Phone: 0300 123 6780
Email: developeras@lancashire.gov.uk
Your ref: 3/2026/0251
Our ref: D3/2026/0251
Date: 5th May 2026

App No: 3/2026/0251
Proposal: Proposed conversion of barn in disrepair to dwelling. Construction of garage and stables.
Location: Fields Farm, Mearley, Pendleton BB7 1PU

PL.04

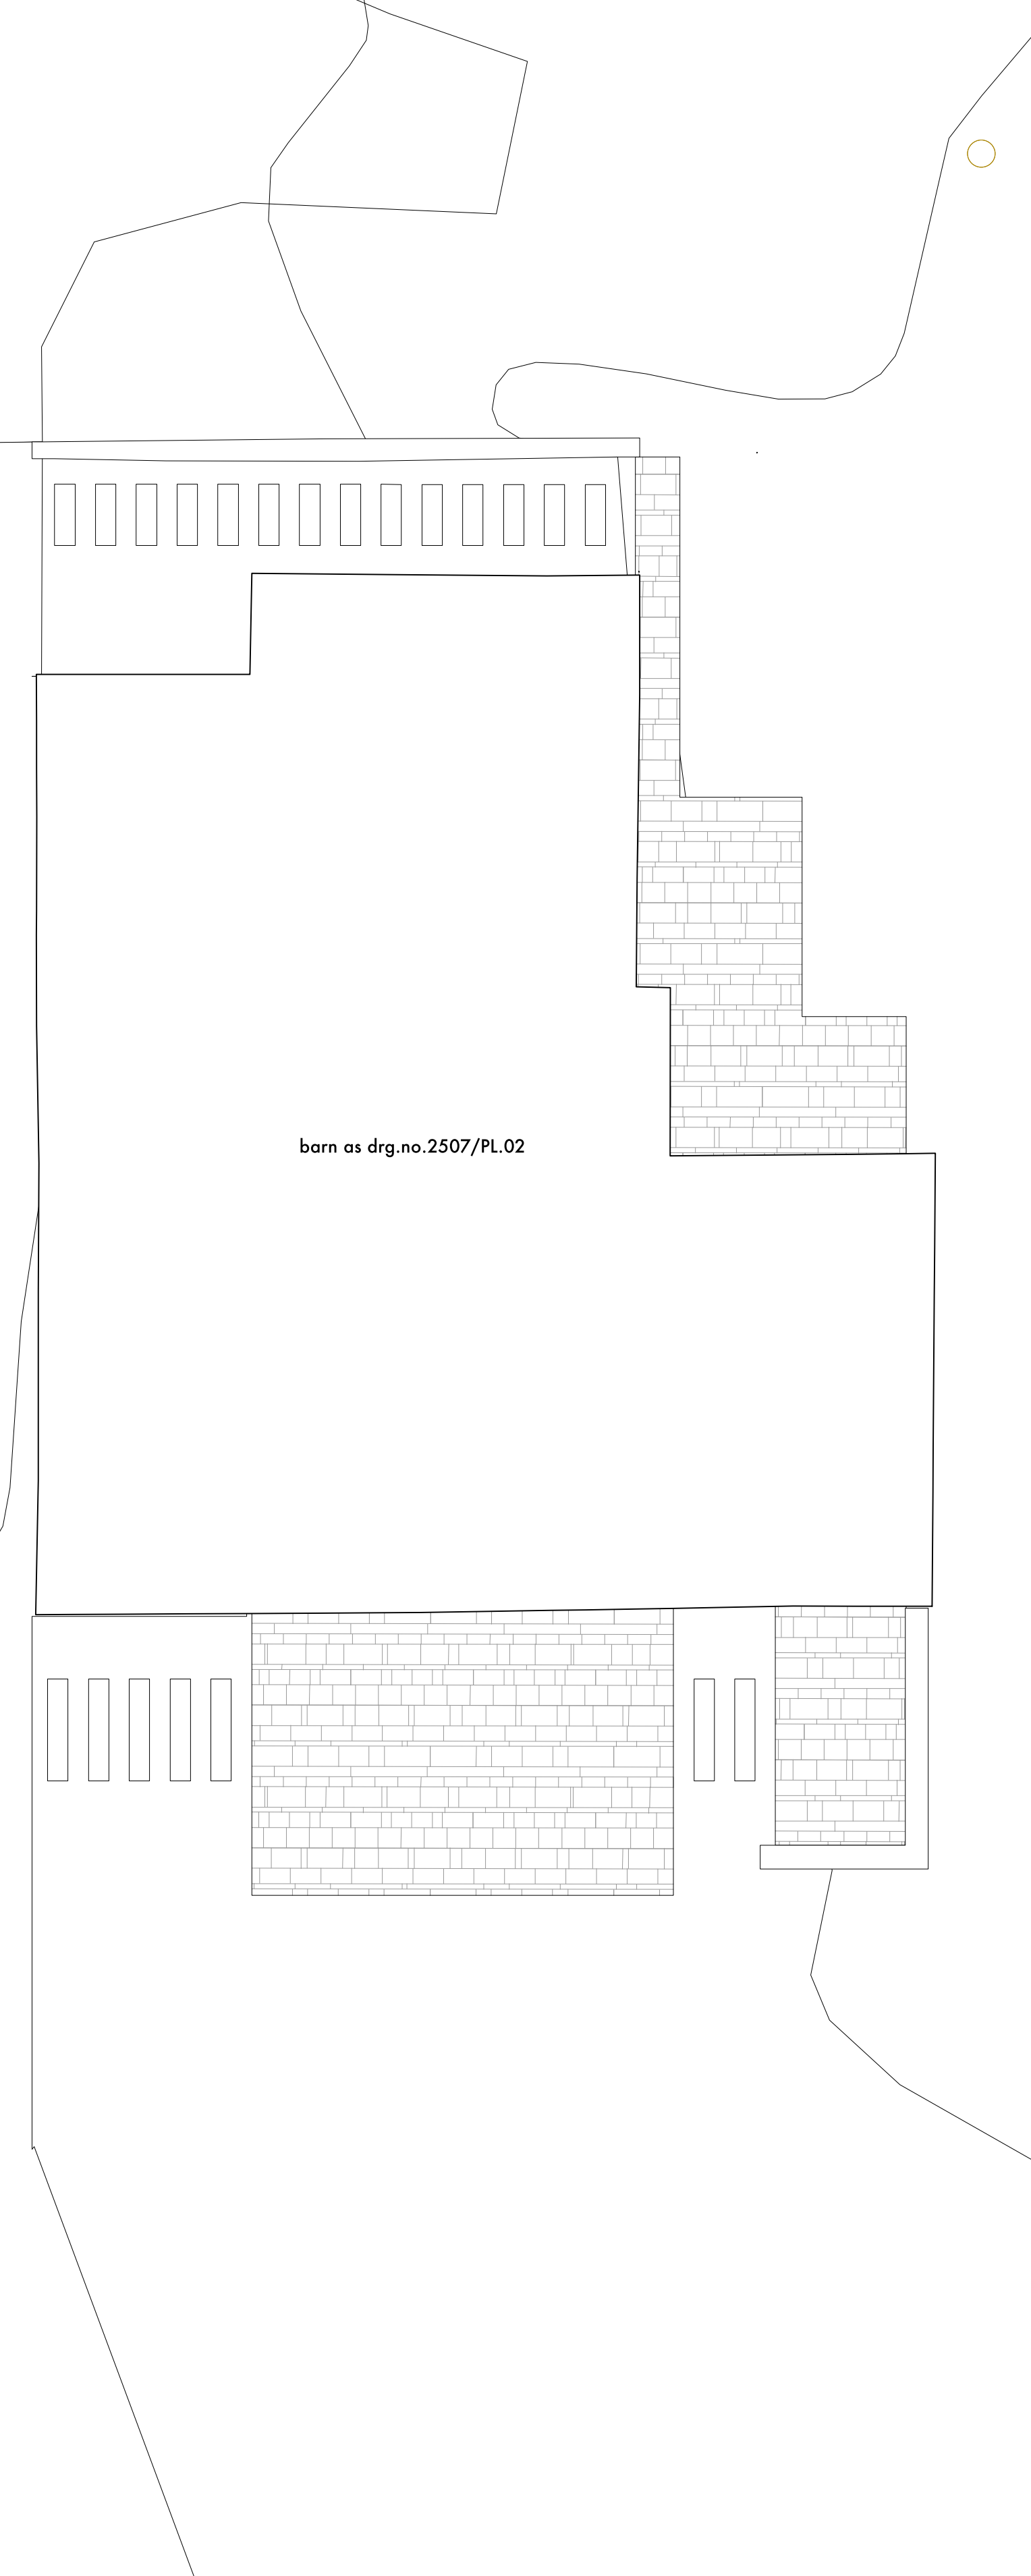
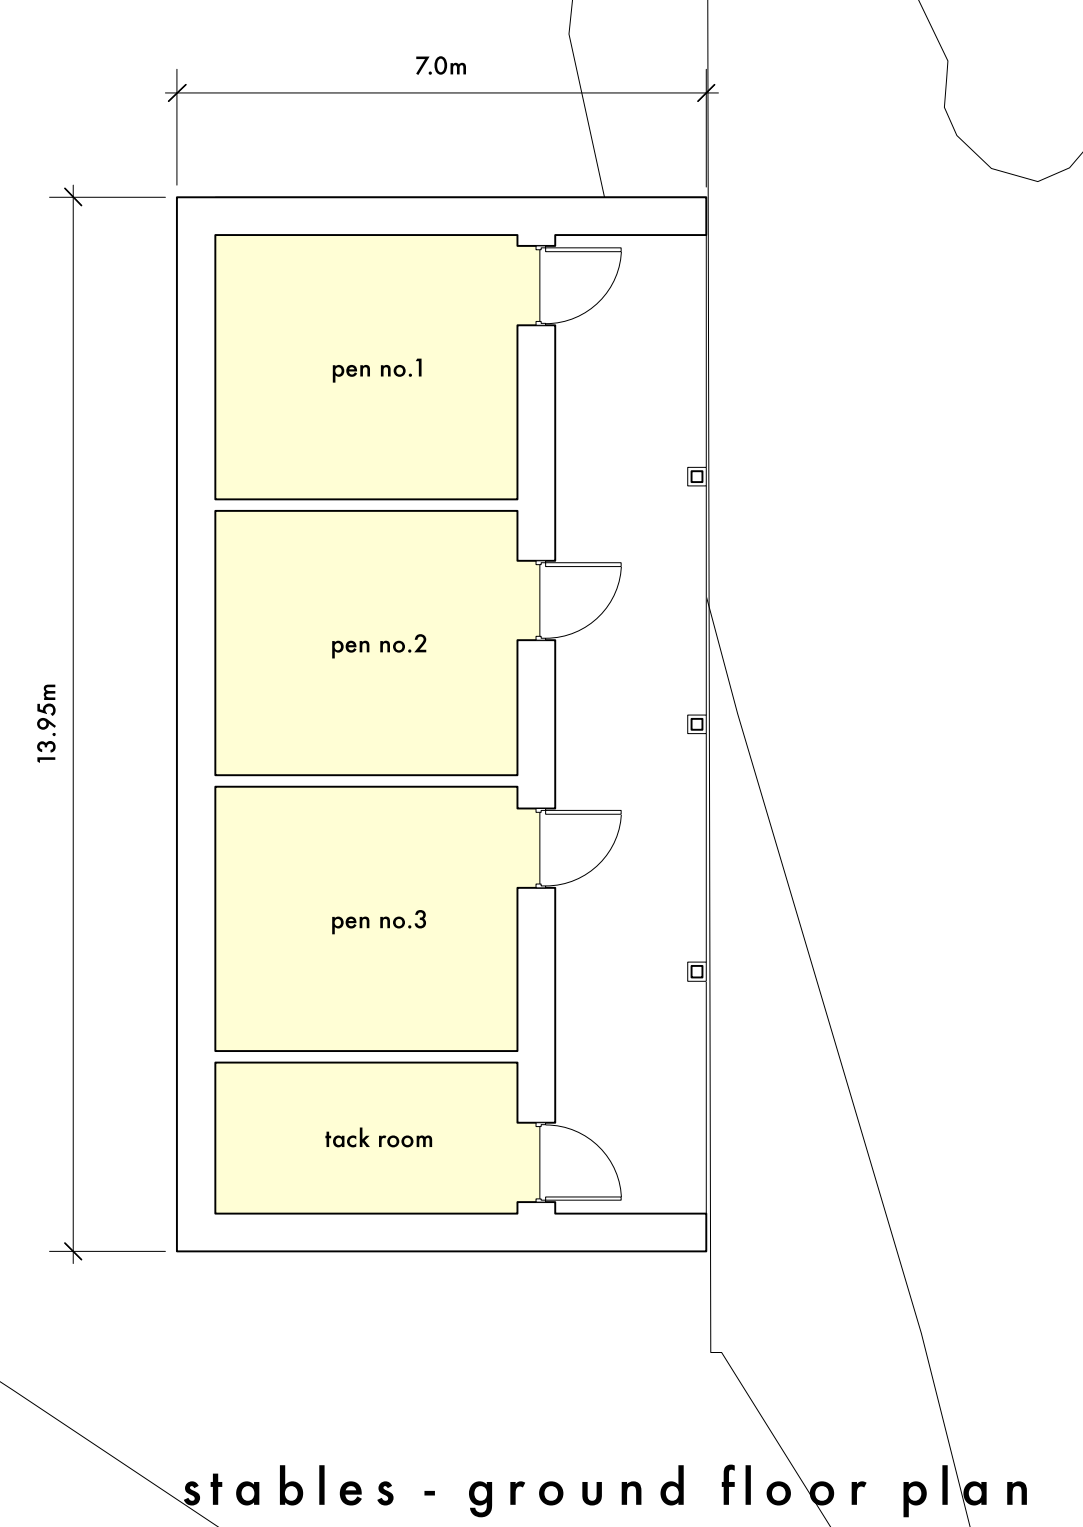
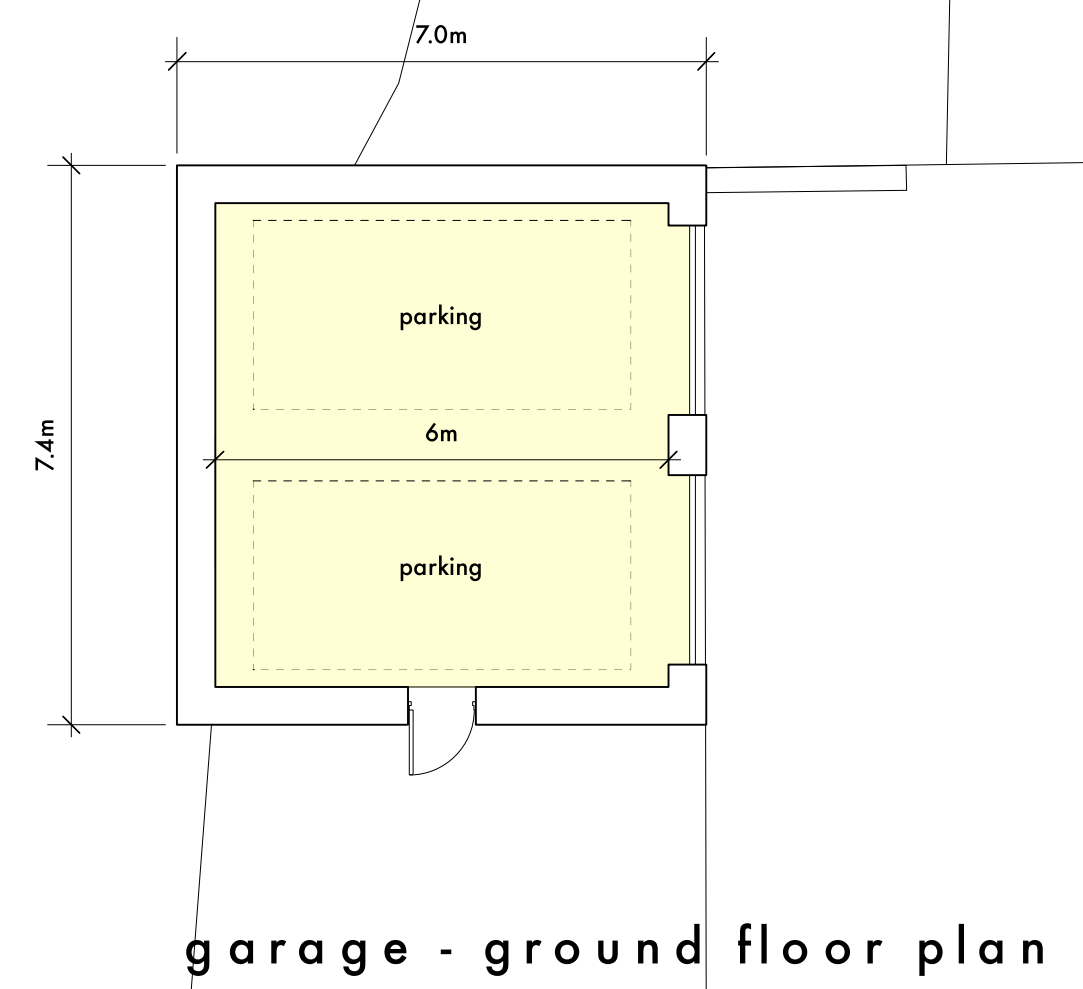
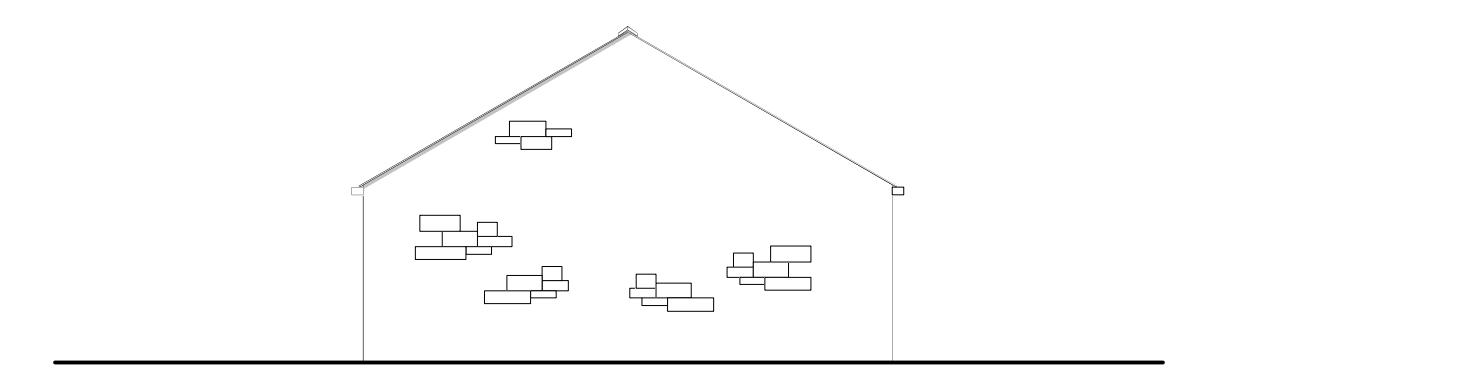
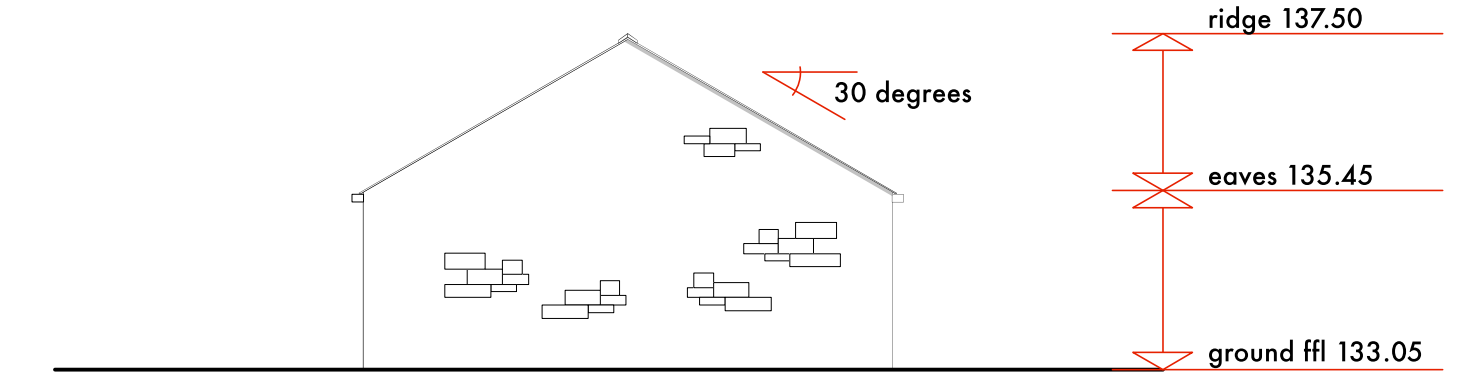
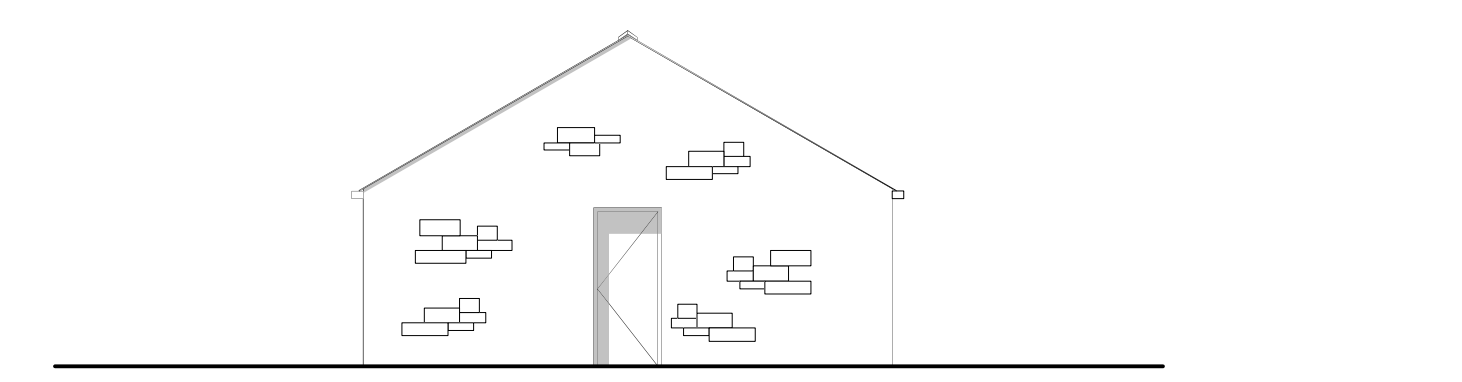
There are 3 parking spaces within the garage which complies with the parking standards for a 5 bedroom dwelling and provides secure cycle parking.

1. Residential traffic accessing the dwelling shall be undertaken from the access land to the southeast, red edged red on the location plan, and not from the A59.
Reason: For highway safety
2. The garage(s)/parking areas hereby approved shall be kept available for the parking of vehicles ancillary to the enjoyment of the household(s) and shall not be used for any use that would preclude the ability of their use for the parking of private motor vehicles, whether or not permitted by the provisions of the Town and Country Planning (General Permitted Development) Order 2015 or any order amending or revoking and re-enacting that order.
Reason: To ensure that adequate parking provision is retained on site
